From: Martin Hill <Martin.Hill@arun.gov.uk>
Sent: 06 April 2022 14:38
To: Planning.Responses <Planning.Responses@arun.gov.uk>
Subject: RE: Planning Consultation on: BR/61/22/PL

Comments from Private Sector Housing:

Application No: BR/61/22/PL

Description of Works: Change of use to 5 bed house in multiple occupation.

Title
Floor Plans as Proposed

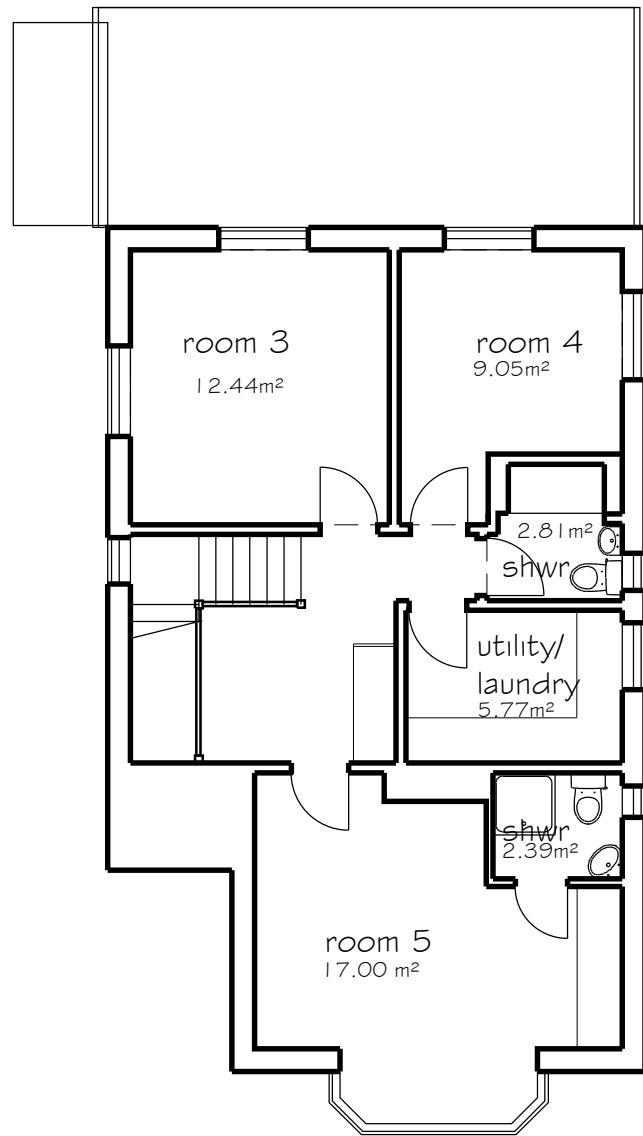
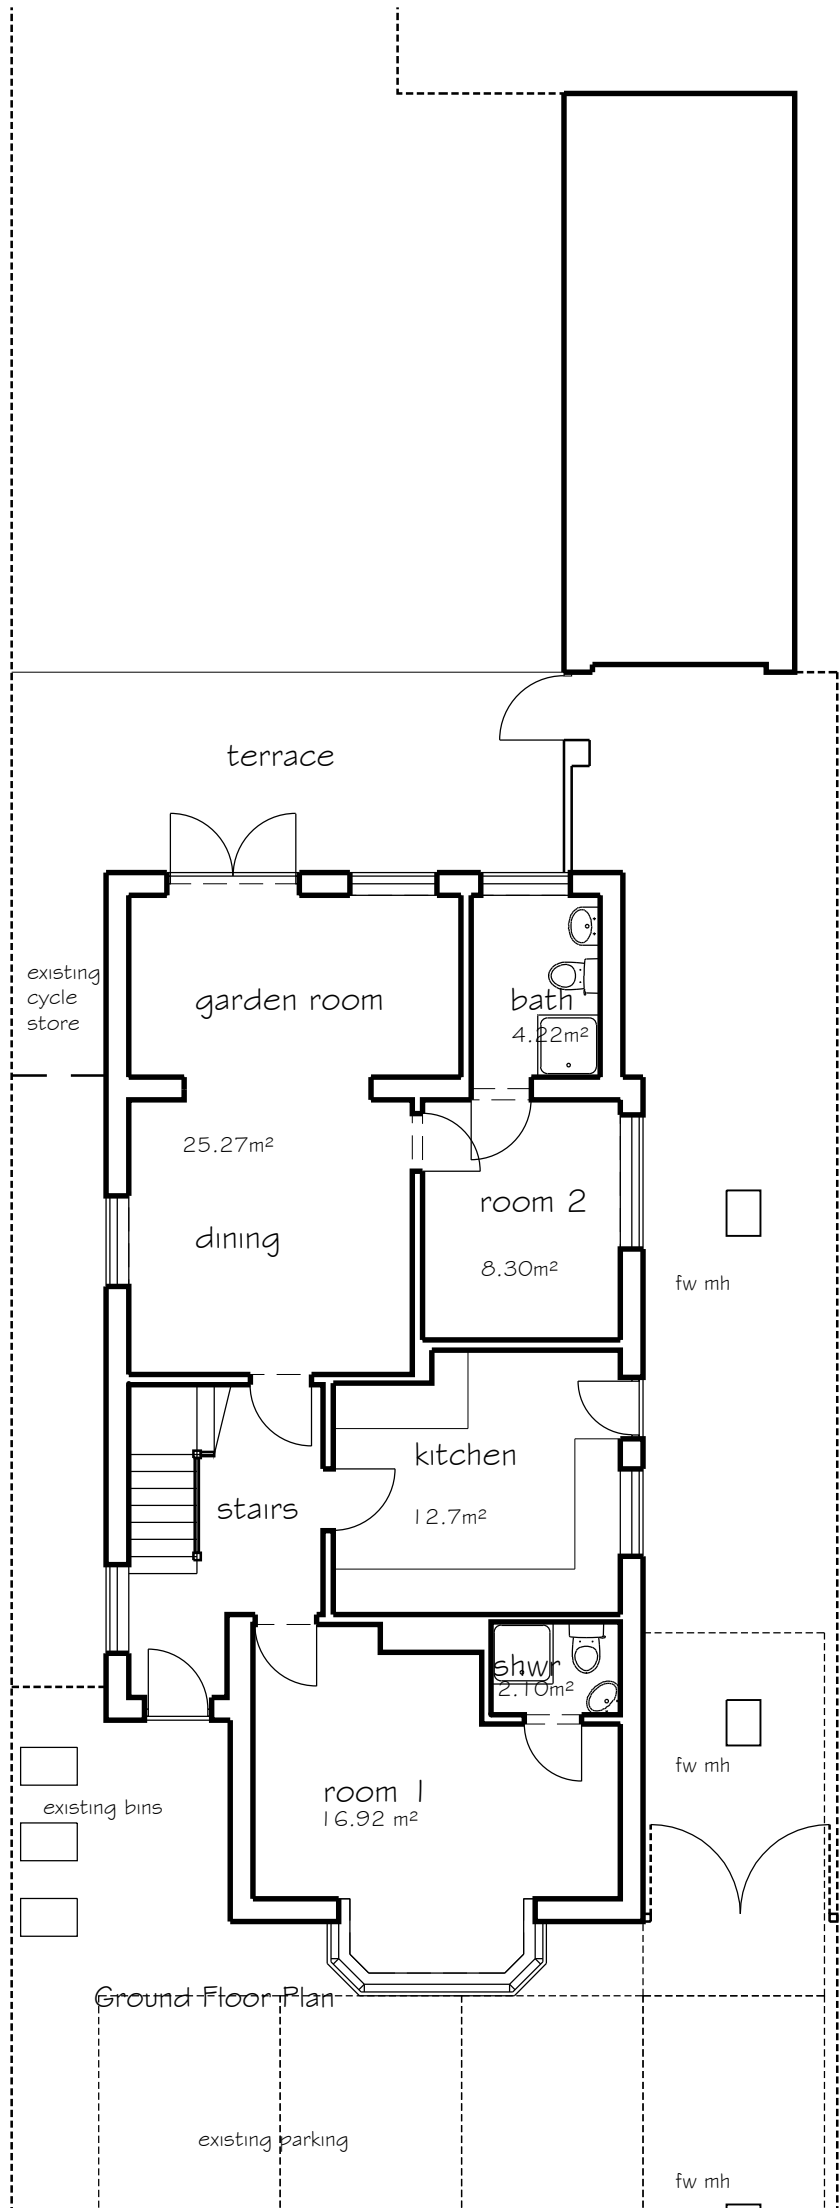
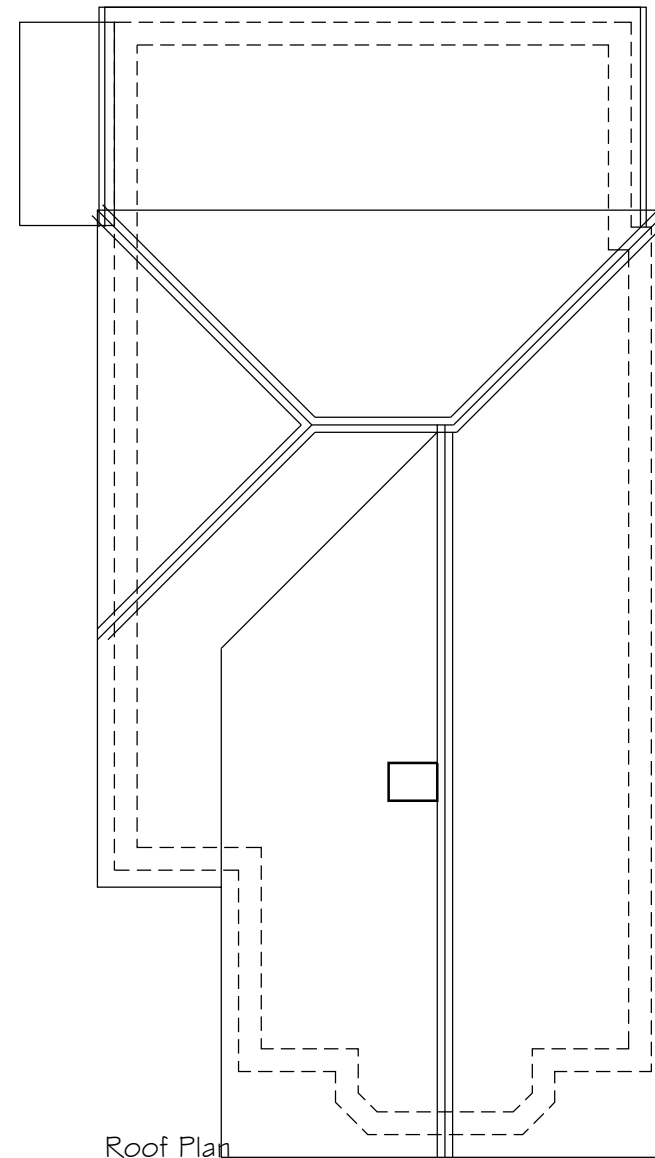
- A room where the only escape route is through another room is termed an “inner room” and poses a risk to its occupiers if a fire starts unnoticed in the outer room. The escape routes from bedroom 2, as detailed on the proposed plans (but understood to be designated as bedroom 1 from a recent property visit) is via the lounge area. This can be overcome by ensuring that the window in bedroom 2 is an escape window, with a smoke detector located in both bedroom 1 and the lounge area and an FD30S fire door separating the lounge area and bedroom 1. The applicant must also ensure that the external escape route leads to a place of ultimate safety without the need for a key, code or card to exit the gate serving the rear garden to driveway area.

- 30min fire resisting escape route, which would include providing a 30 minute fire resisting and self-closing fire door to the kitchen, lounge area and all bedrooms. Fire doors must meet the minimum standard of FD30S, to include an overhead self-closing device, intumescent strips and cold smoke seals, thumb turn opening devices and be fitted with 3 fire-rated hinges.
- Grade D1, LD2 fire alarm and detection system,
 - o interlinked mains wired smoke alarms with integral tamper-proof battery back-up located throughout the escape route, including in the understairs cupboard containing the mains electrics.
 - o Interlinked smoke alarms with integral tamper-proof battery back up in each bedsit and lounge/dining areas
 - o Interlinked heat alarms with integral tamper-proof battery back-up to be located in the communal kitchen
 - o Fire blanket to be provided in each shared kitchen
